Online Comment

Application H16-1114-16
Location ALDI STORES LTD ST THOMAS ROAD SPALDING PE11 2XY
Proposal Proposed signage

Name Spalding Civic Society
Address 19 Ladywood Road PE11 2DA

TITLE PROPOSED ELEVATIONS

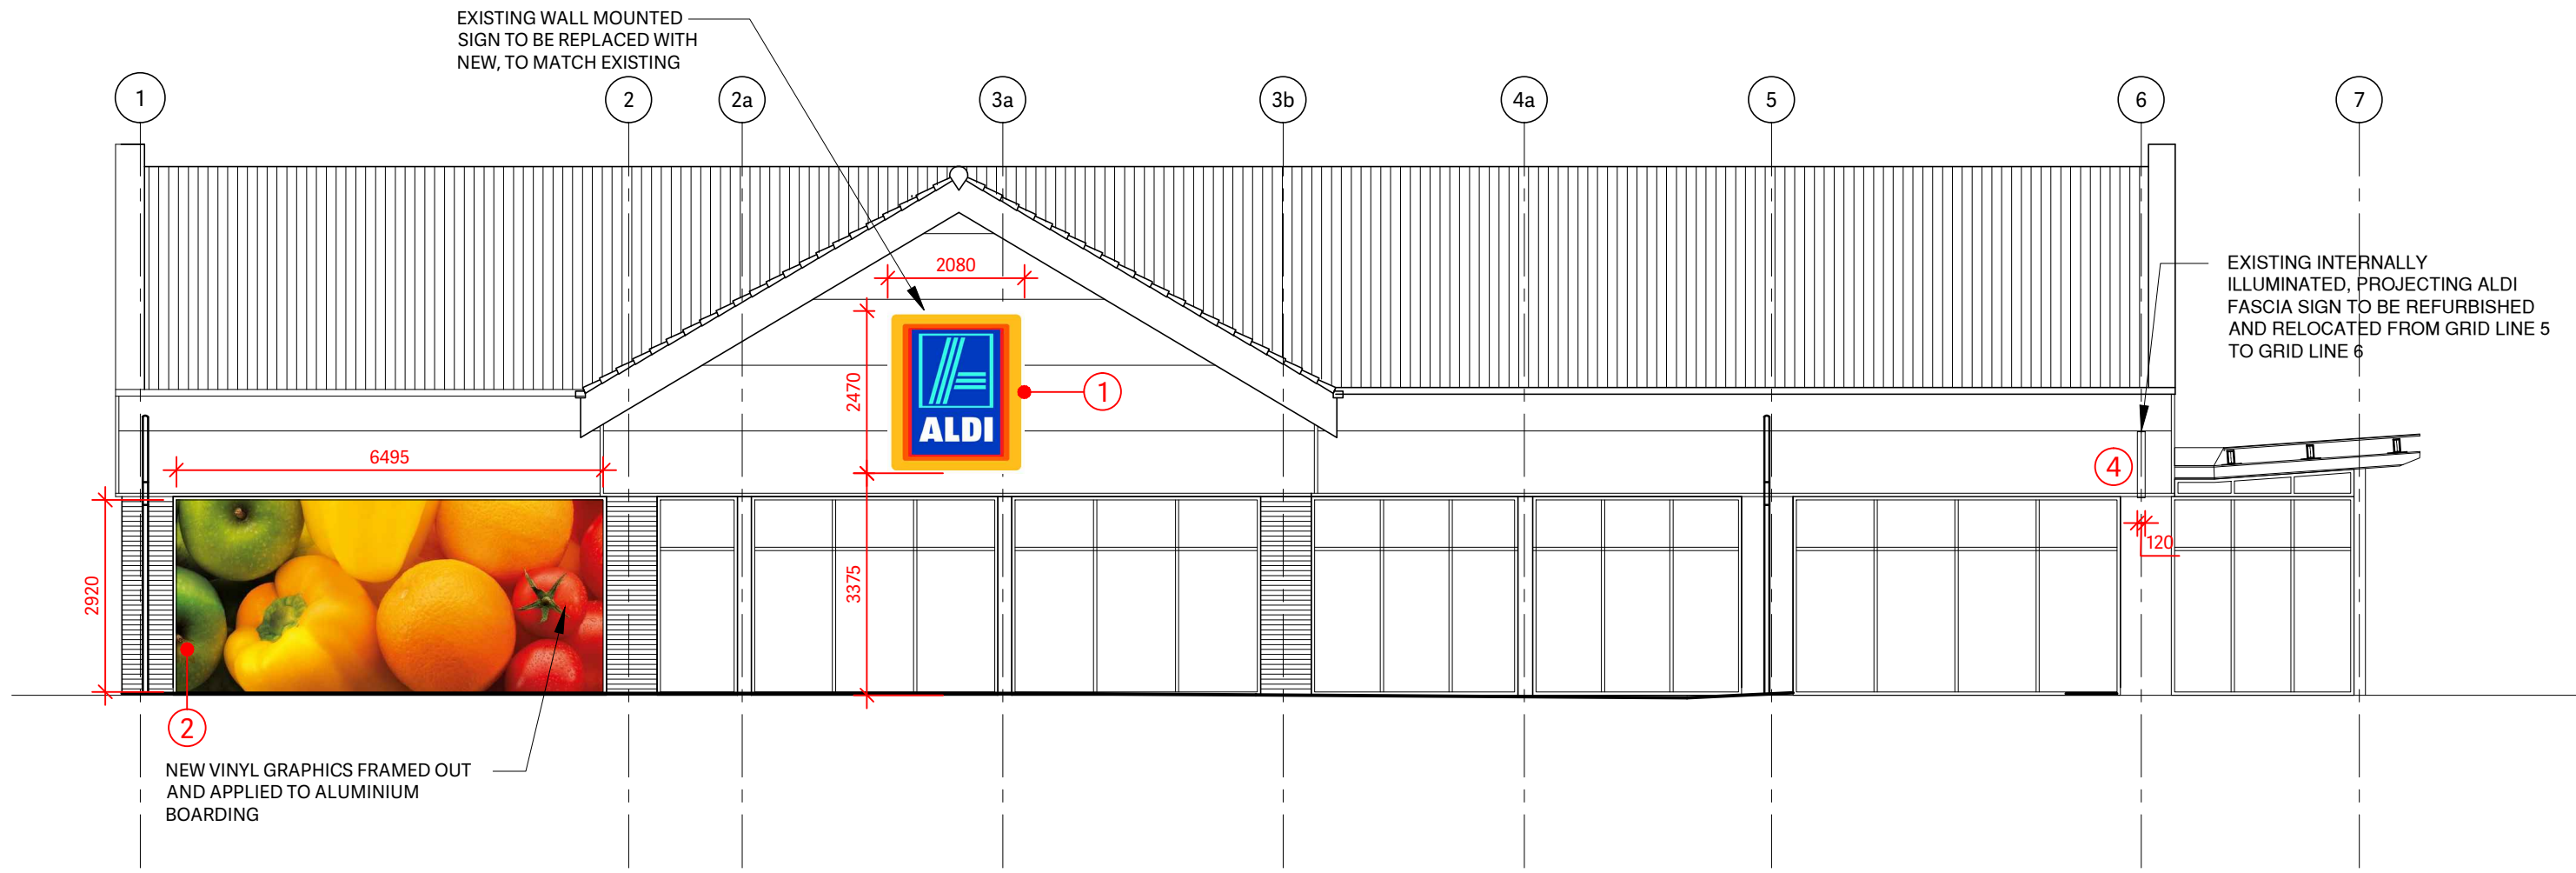
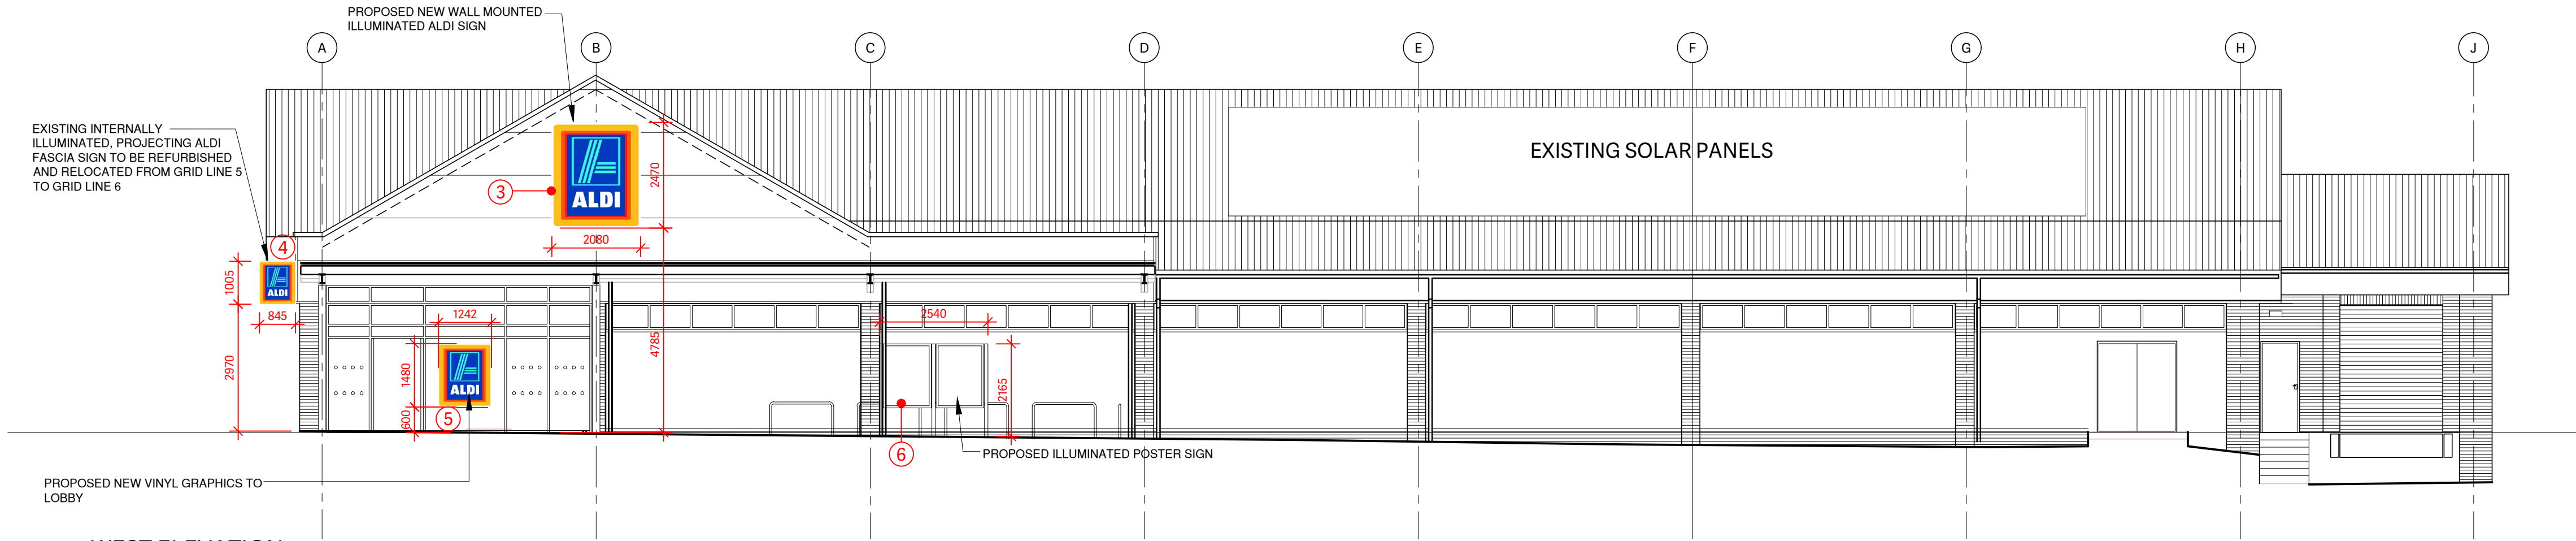
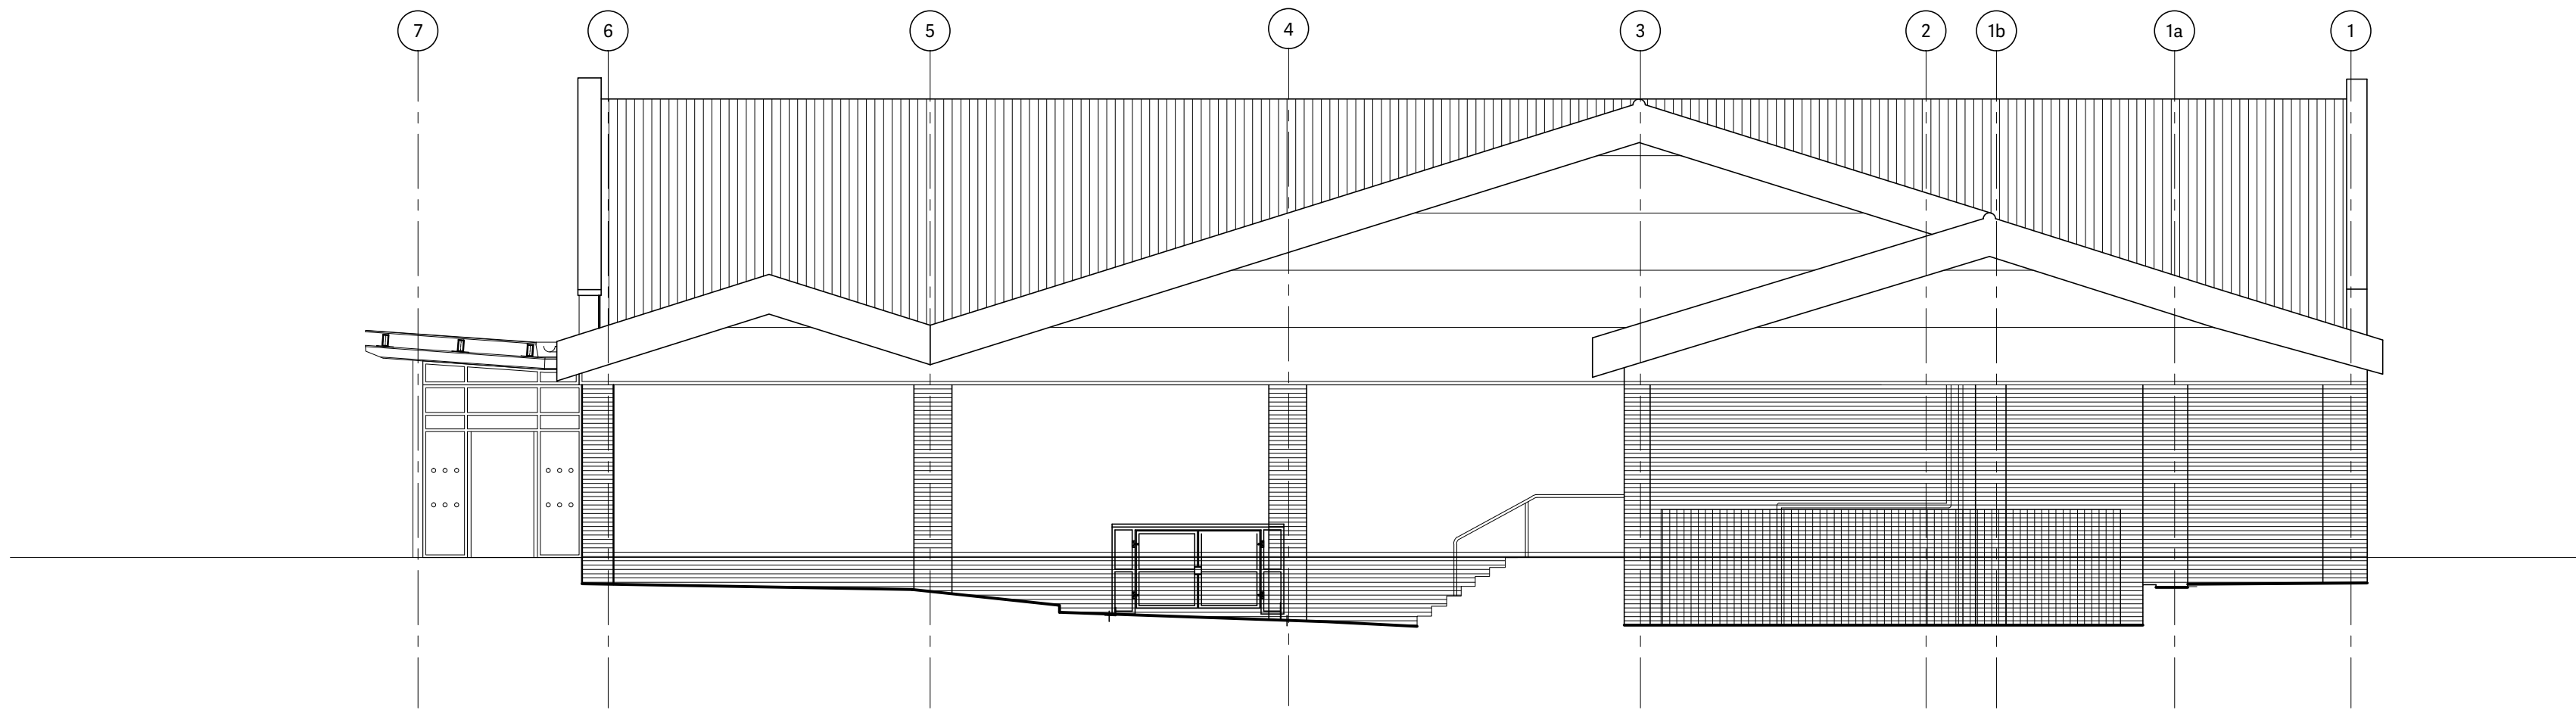
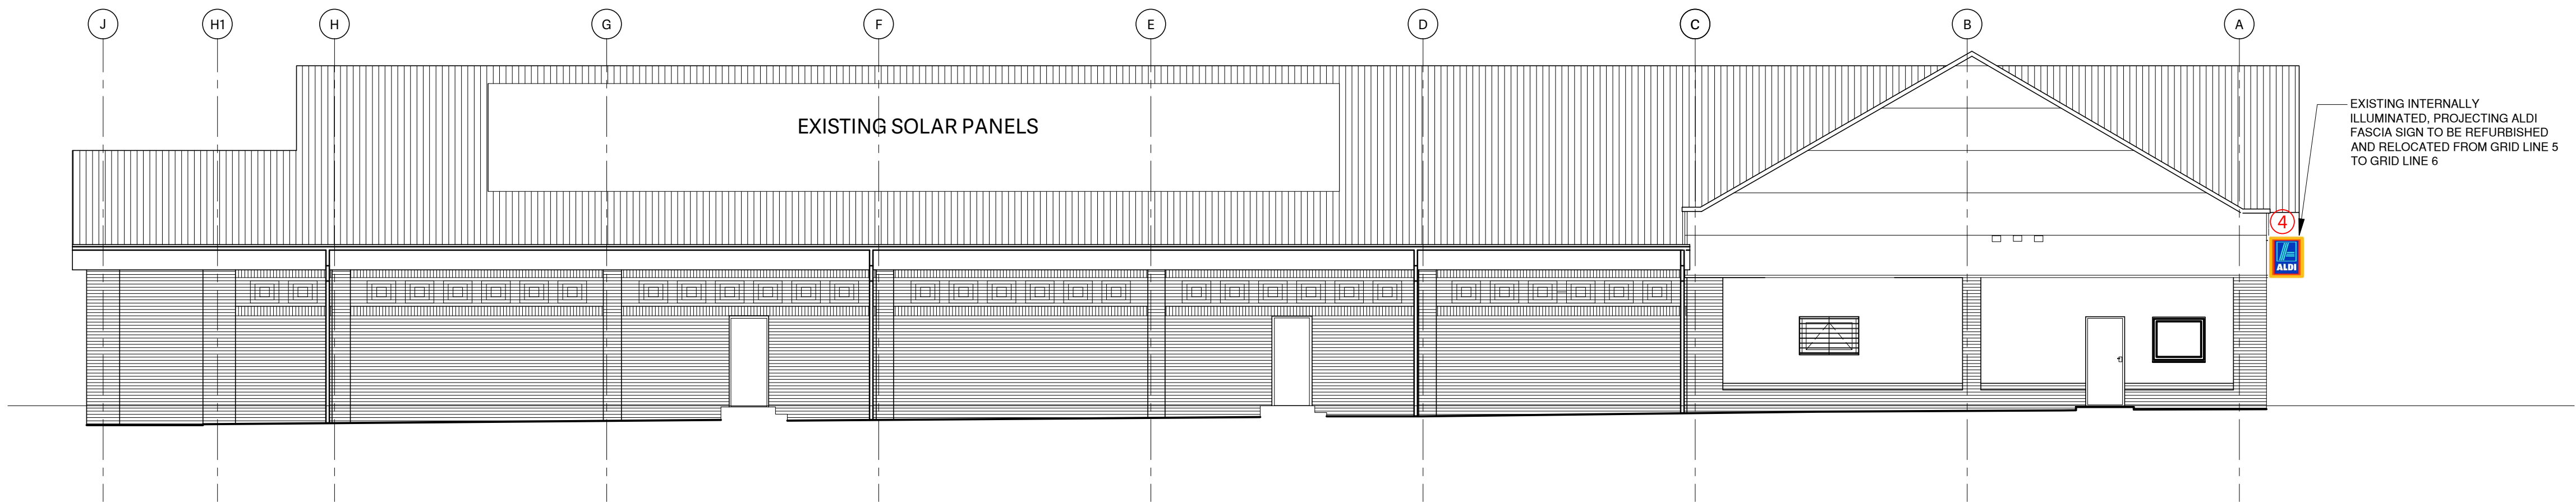
We object to the proposed garish vinyl panel, which continues the current practice of increasing installation of ugly unnecessary vinyl panels on shop fronts, to which we have objected before. In the case of Aldi, it is particularly unfortunate that it would cover up patterned brickwork. Refusing this application would give the opportunity to begin to improve the visual aspect of Winsover Road.
